**CITY OF ALBUQUERQUE  
PLANNING DEPARTMENT  
August 12, 2015  
DRB Comments**

**PROJECT # 1003871**

**APPLICATION # 15-70276**

**RE: Lot B-1, Block 4, La Cuesta Subdivision**

1 OF 2

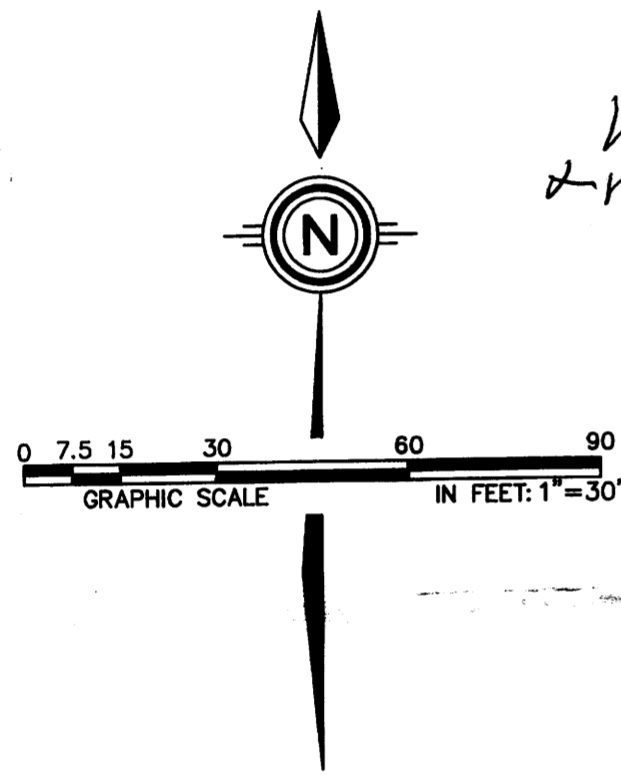
A clear exhibit (sharper back/ white drawing or much lighter photo) is needed to show relationship of proposed lot lines and easements vis a vis existing improvements (curb cuts, drive aisles, etc). The proposed vacated easement needs to be graphically shown on plat drawing (not just referred to by note on Sheet 1).
